Table 1 – Response to Submissions Received During Exhibition

Note: The Responses to Submissions Received during Exhibition have addressed the modified Project Application as they apply to the amended site area.

LAYOUT PLAN

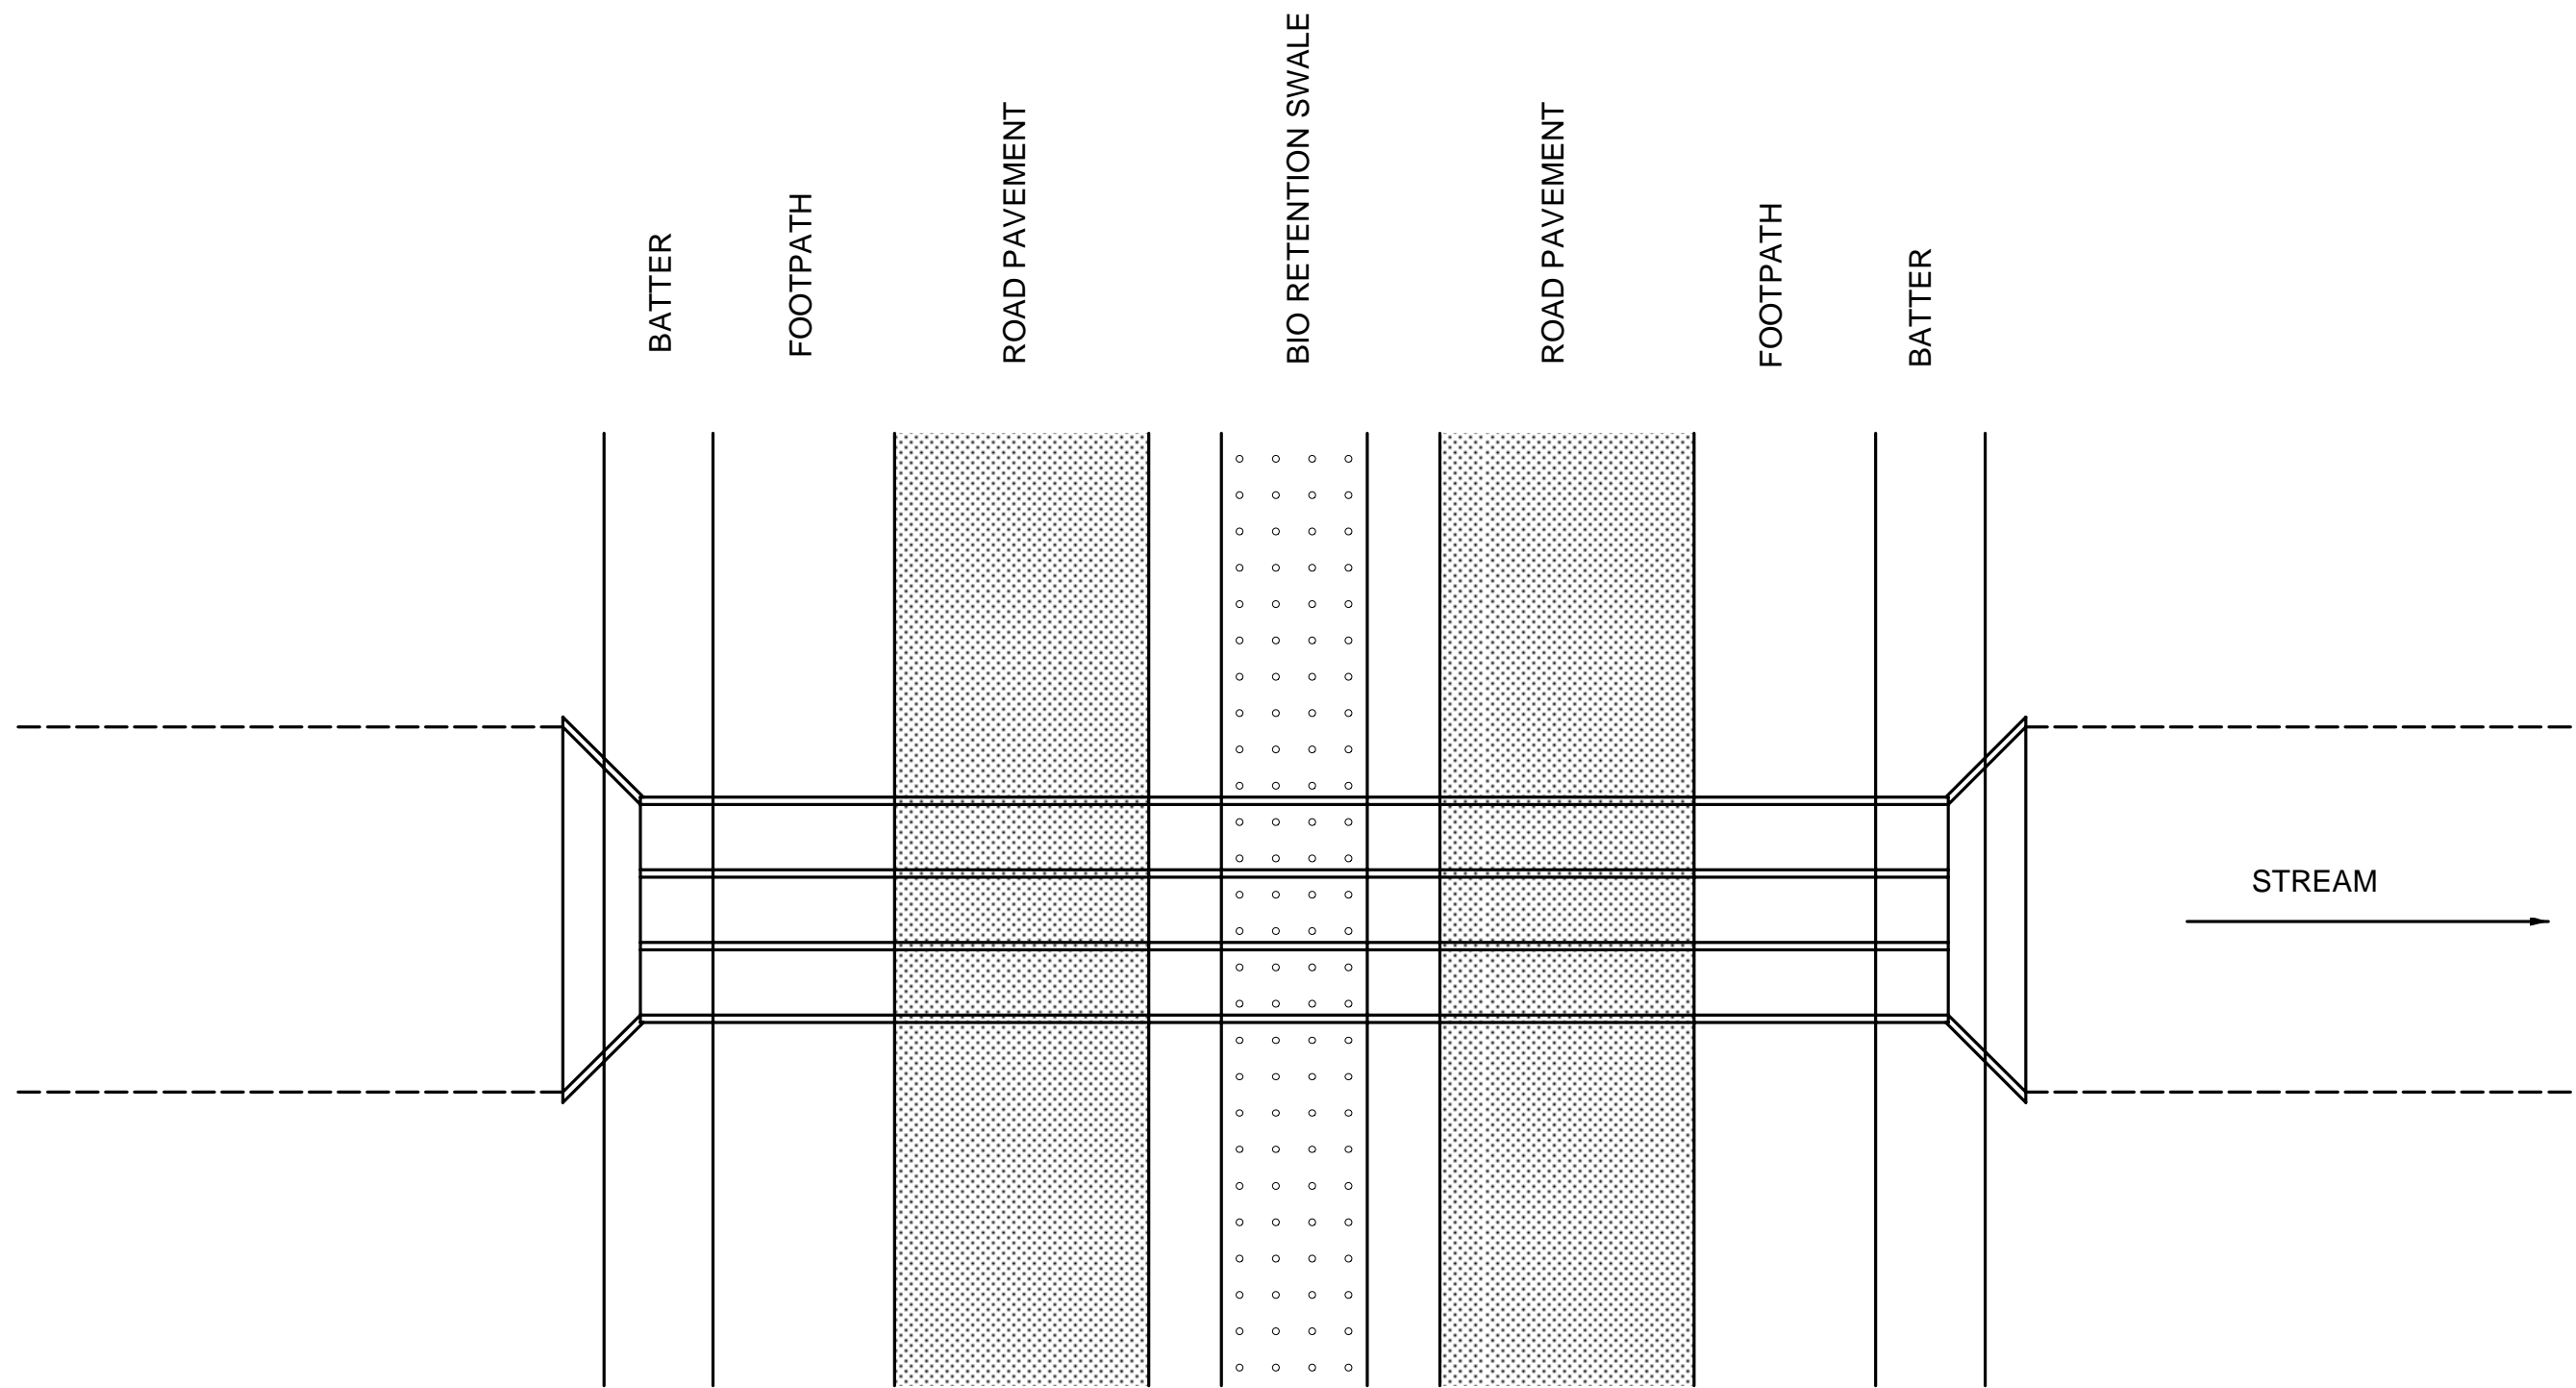
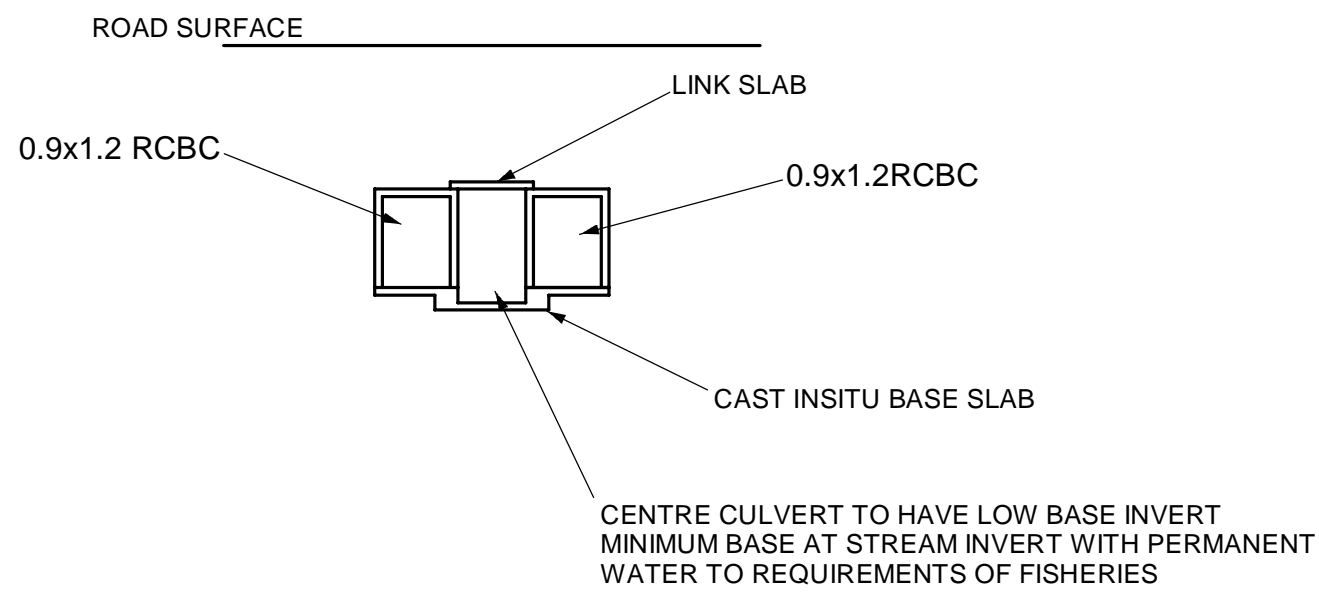
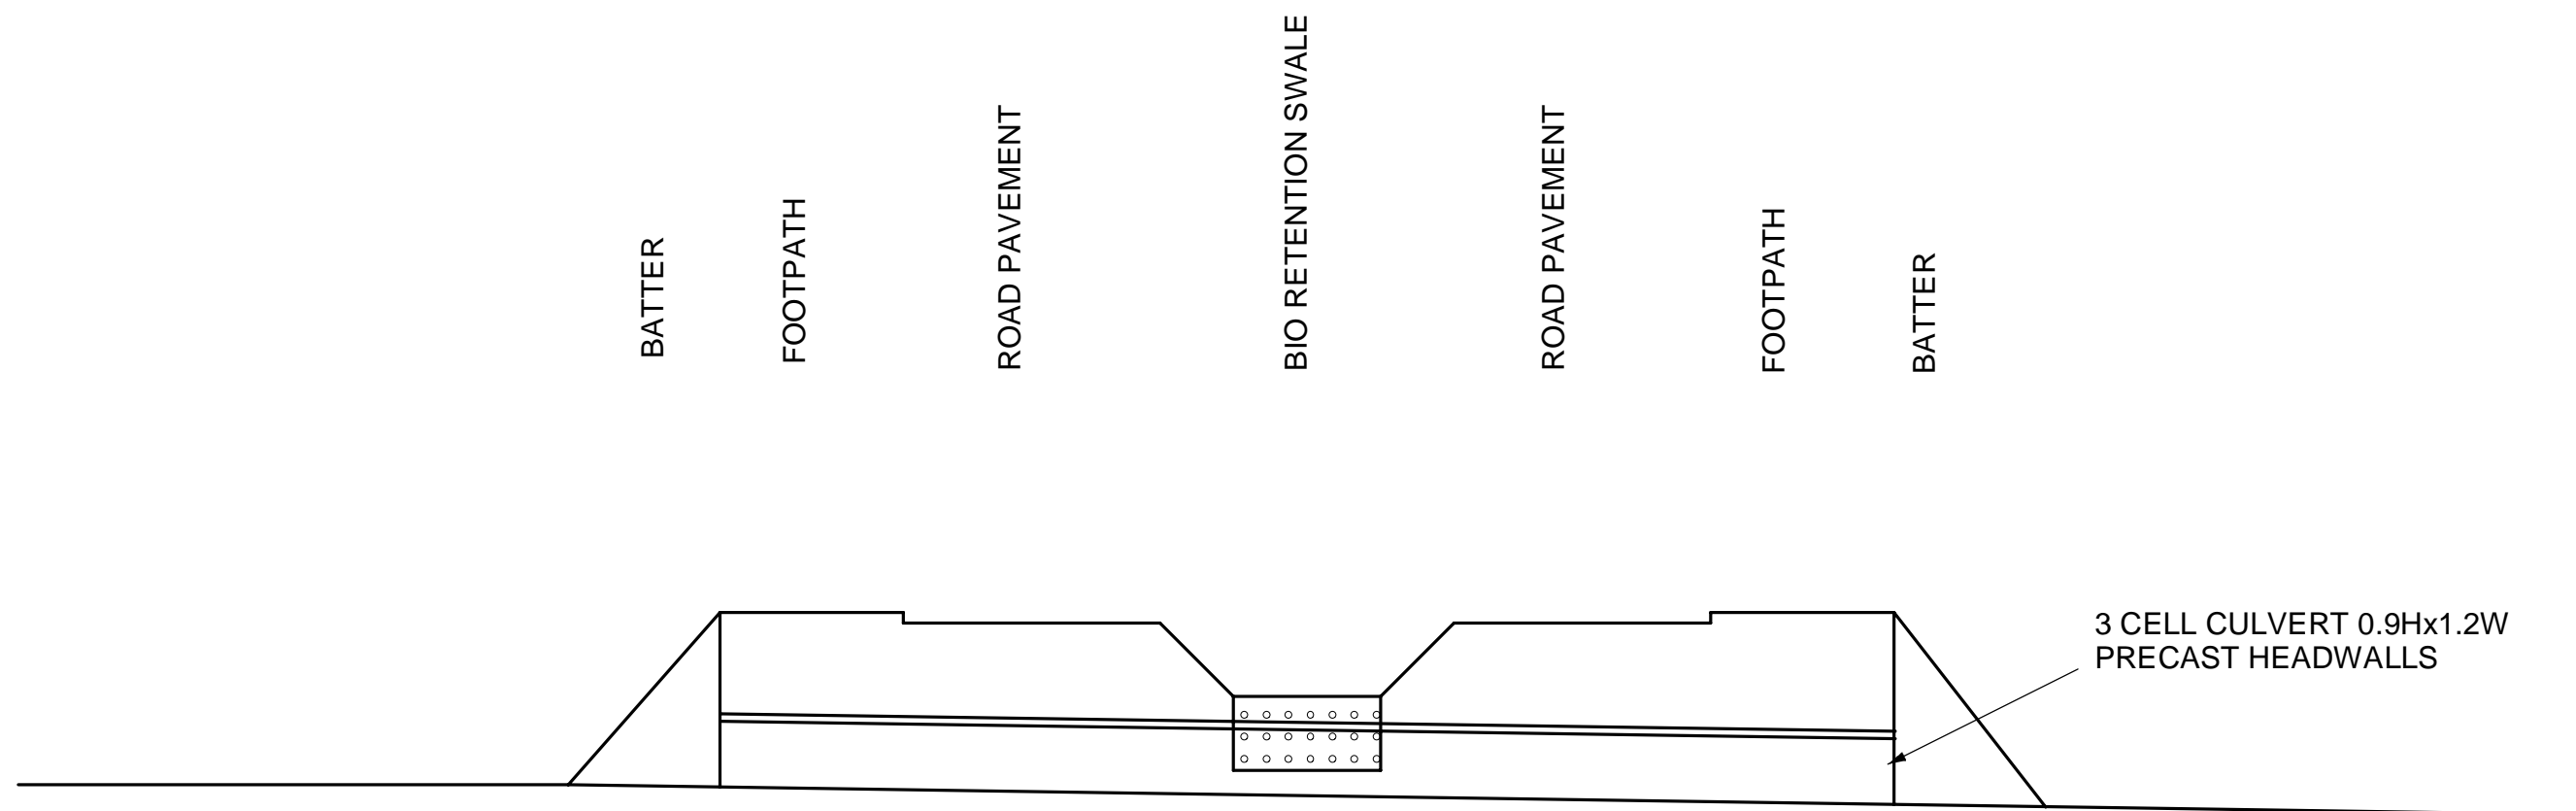
Agency / contact date	Issue Raised	Response	Change to SoC?
	<p>(CRZ) along the 1st order watercourse and 2nd order watercourse on the site however it does not include a Vegetated Buffer (VB). In accordance with the NOW Guideline, 1st order, 2nd order, 3rd order and greater watercourses comprise two distinct zones namely; a Core Riparian zone (CRZ) and a Vegetated Buffer (VB).</p> <ul style="list-style-type: none"> Figure 5 shows it is proposed to locate bioretention basins within riparian land. The locating of basins within riparian land is not supported in principle. Stormwater is an urban impact and needs to be dealt with within the urban zone and should not be transferred to the riparian environmental footprint. In accordance with the NOW Guideline, stormwater structures need to be located outside the riparian areas (i.e. outside the CRZ and the VB). 		
	<p>The VMP outlines proposed rehabilitation and revegetation along the existing watercourses which is supported in concept by NOW however needs to be considered in terms of the application of the CRZ and VB. The EA also mentions the requirement of a creek crossing on site. It is proposed to use a box culvert in accordance with the 'Guidelines for Controlled Activities', which NOW supports.</p>	Noted.	No
